re: Grading and Site Servicing Plans Review
Proposed Residential Building
230-232 Lisgar Street – Ottawa, Ontario
to: 230 Lisgar Street Inc. – Mr. Albert Falsetto – a.falsetto@rogers.com
to: Fotenn – Ms. Jillian Simpson – simpson@fotenn.com
date: May 23, 2023
file: PG6401-MEMO.02 Revision 1

Further to your request and authorization, Paterson Group (Paterson) prepared the current memorandum to provide a review from a geotechnical perspective for the grading and site servicing plans for the proposed residential building at the aforementioned site. This memorandum should be read in conjunction with Paterson Geotechnical Report PG6401 -1 Revision 1 dated November 8, 2022.

DRAWING NAME
GRADING AND EROSION & SEDIMENT CONTROL PLAN

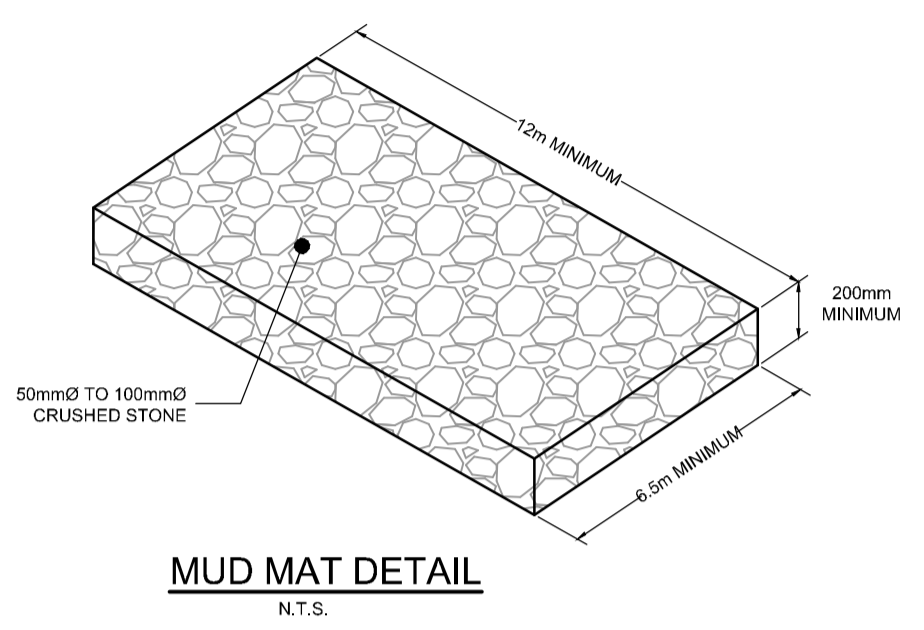
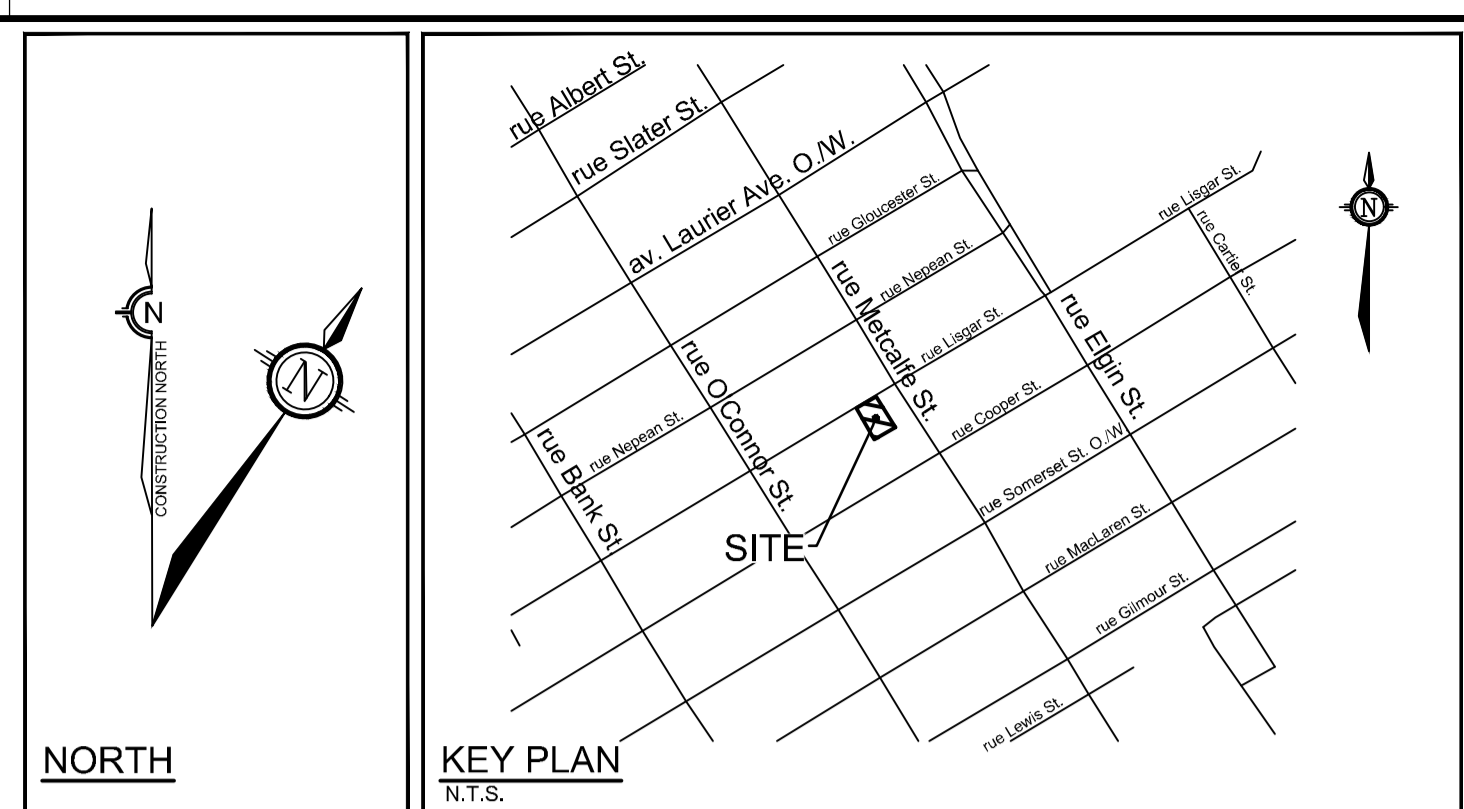
Based on our review of the above noted grading plans, the proposed grade raises within the aforementioned site are within the recommended permissible grade raise of **2.0 m**. No exceedances were noted for any area within the subject site. Therefore, the proposed grade raises are generally acceptable from a geotechnical perspective and will not require the use of lightweight fill at this time.
